Our Ref: Y/75/17/HH

**Town & Country Planning Act 1990 (as amended)
Town & country Planning (Development Management Procedure) (England) Order 2015
Application for Planning Permission for Works or Extension to a Dwelling**

Development Erection of first floor side and rear extension.

Location 7 Mill View Road Yapton

BLOCK PLAN

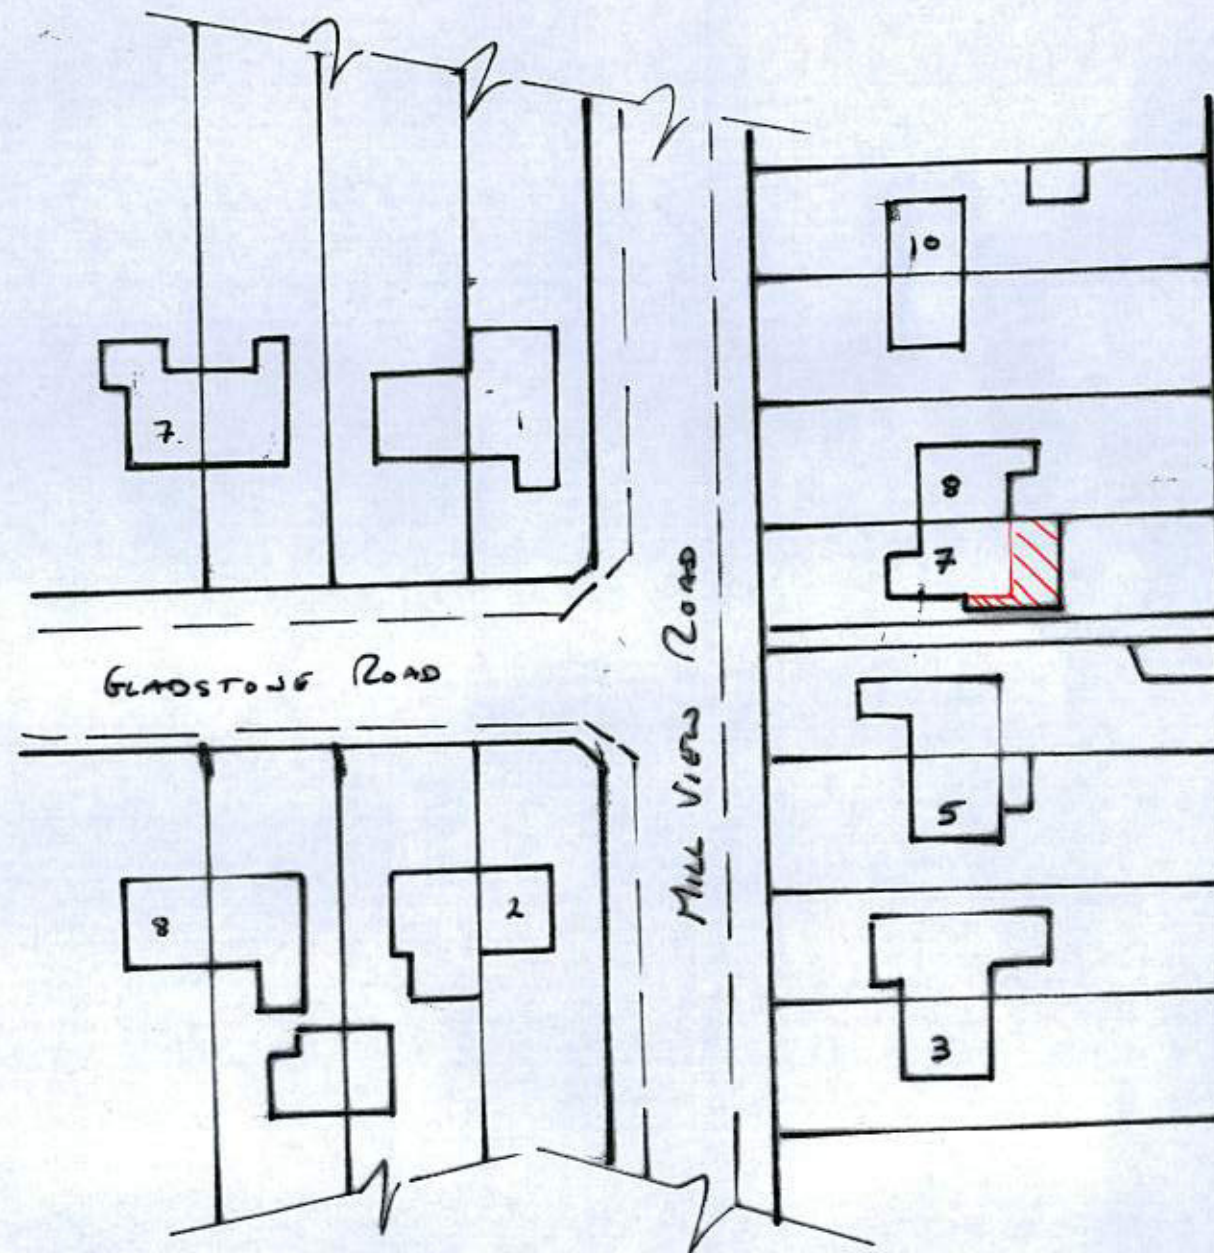
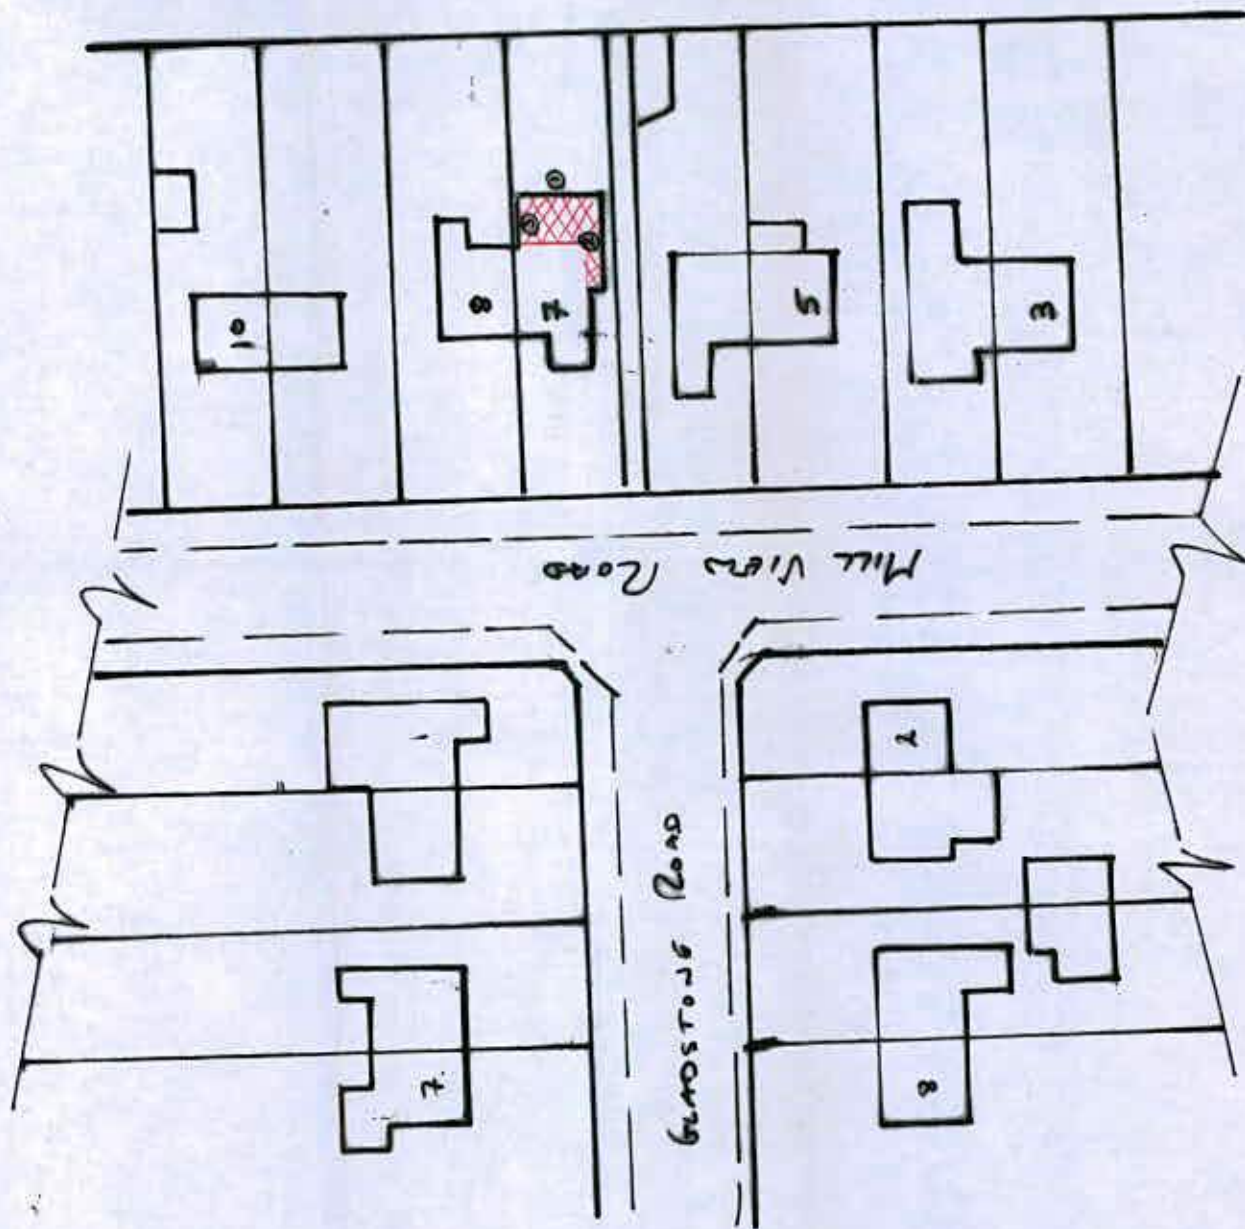
Block Plan - Amend

Please submit 1 electronic or 3 paper copies of an amended block/site plan at a scale of 1:500 or 1:200 to include the dimensions shown from the proposal to each boundary. Further details of what must be included on the plan can be found in the National Validation Requirements.
